Application for removal or variation of a condition following grant of
planning permission. Town and Country Planning Act 1990.
Planning (Listed Buildings and Conservation Areas) Act 1990

Single storey side/front/rear extension, conversion of attached garage to habitable use, and extension and conversion of roof space to habitable use to include 10 side roof lights and gable end window to the rear.

71852/APP/2018/3249

Drawing Title
Proposed Elevations

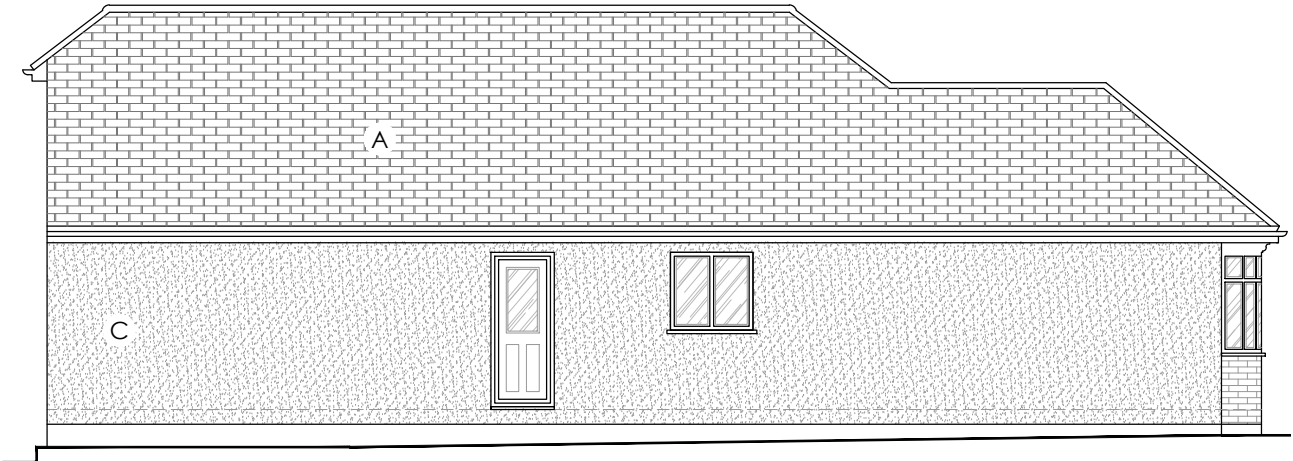
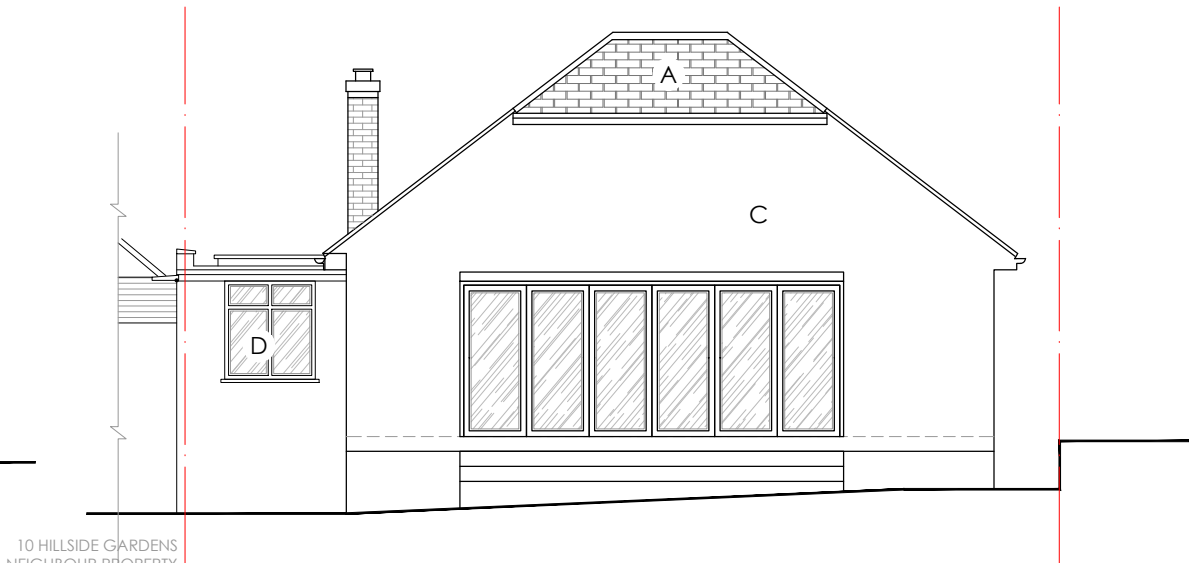
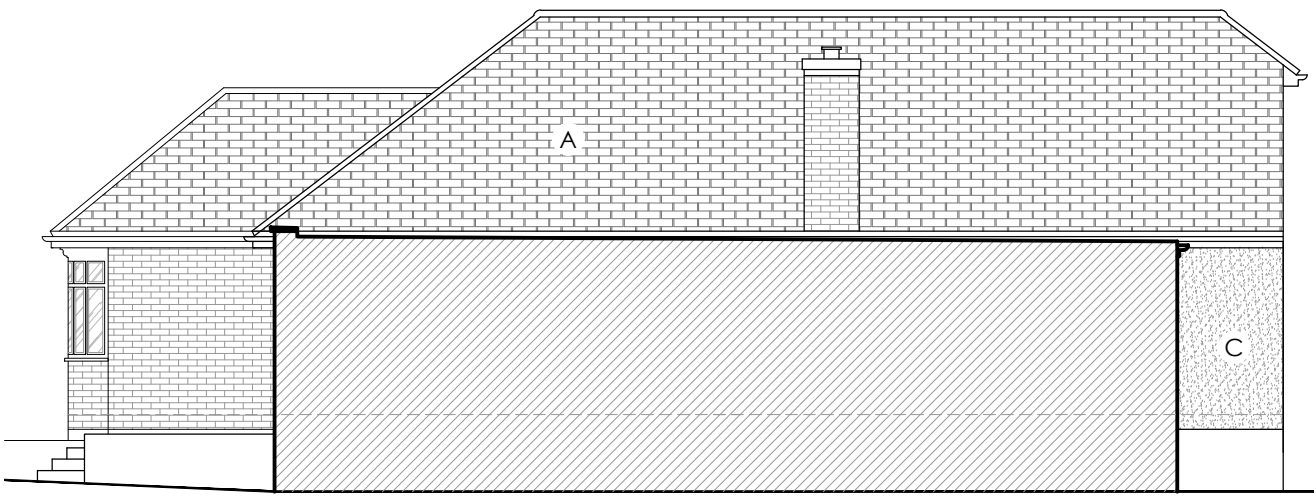
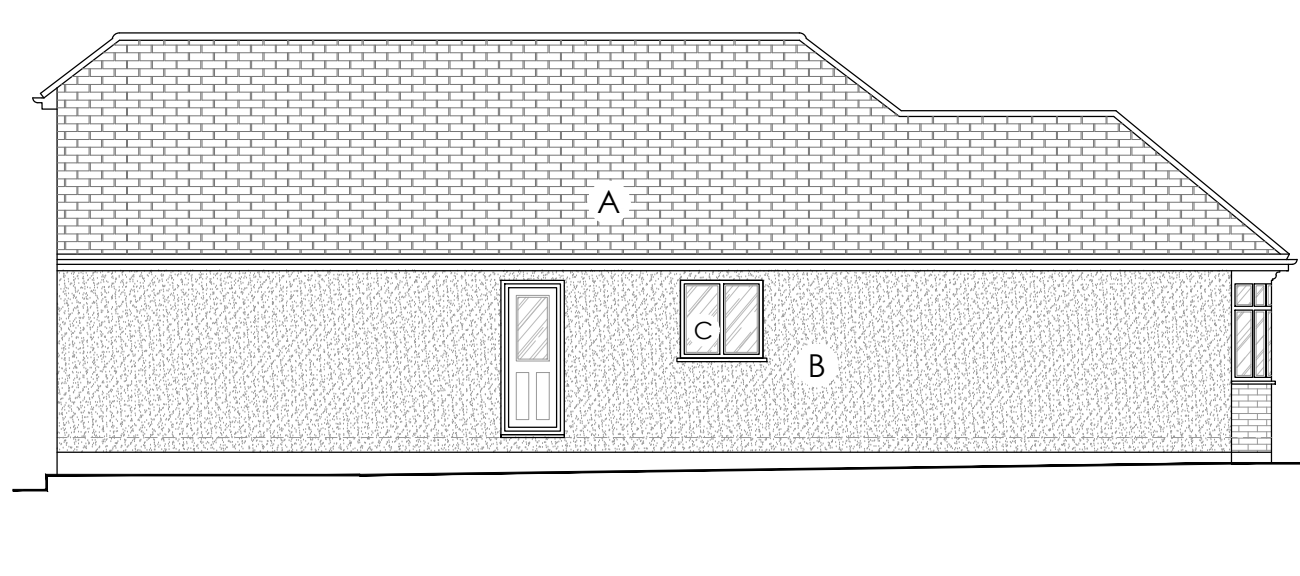
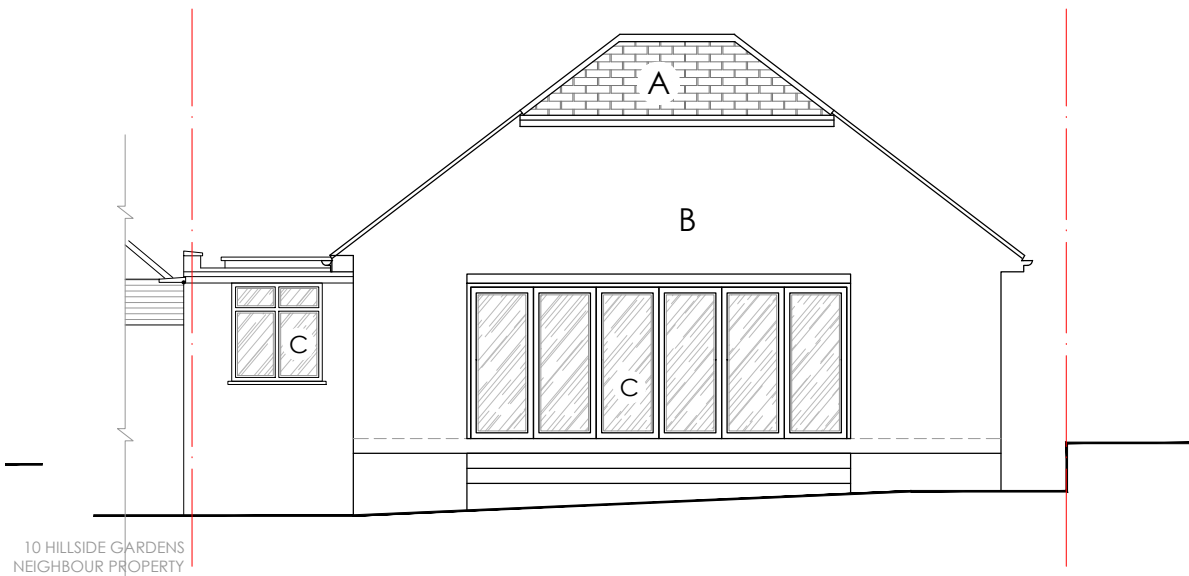
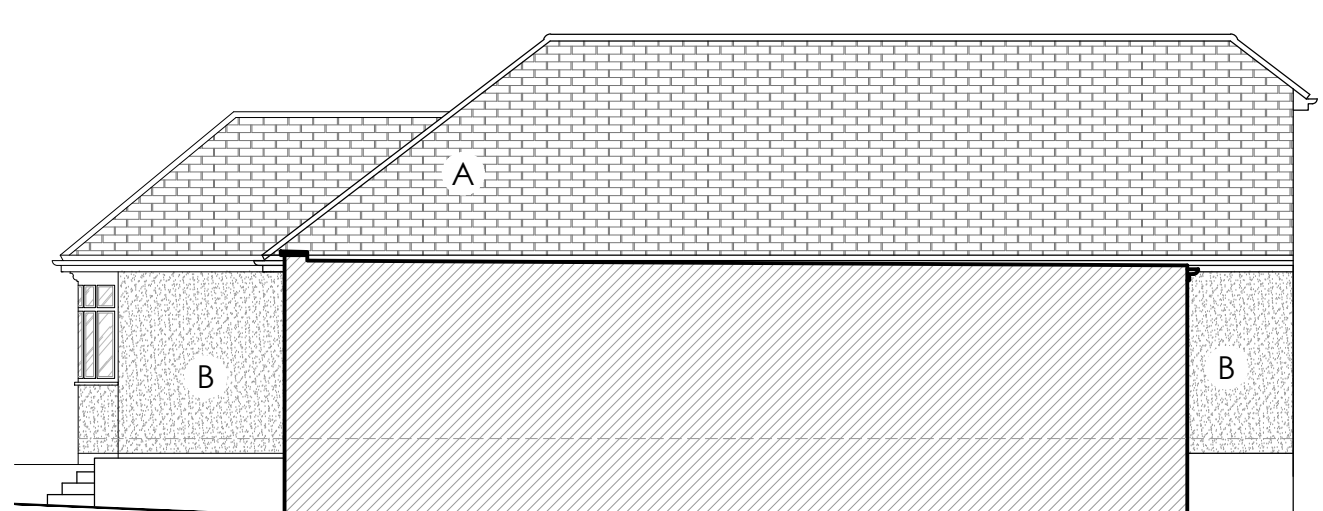
The proposed amendment to architectural finishes:
1. Red facing bricks to white monocouche render.
2. Red roof tiles to Slate roof tiles
2. White UPVC windows to anthracite UPVC windows

In keeping with the streetscape and to provide contemporary durable finishes to add longevity to architecture.
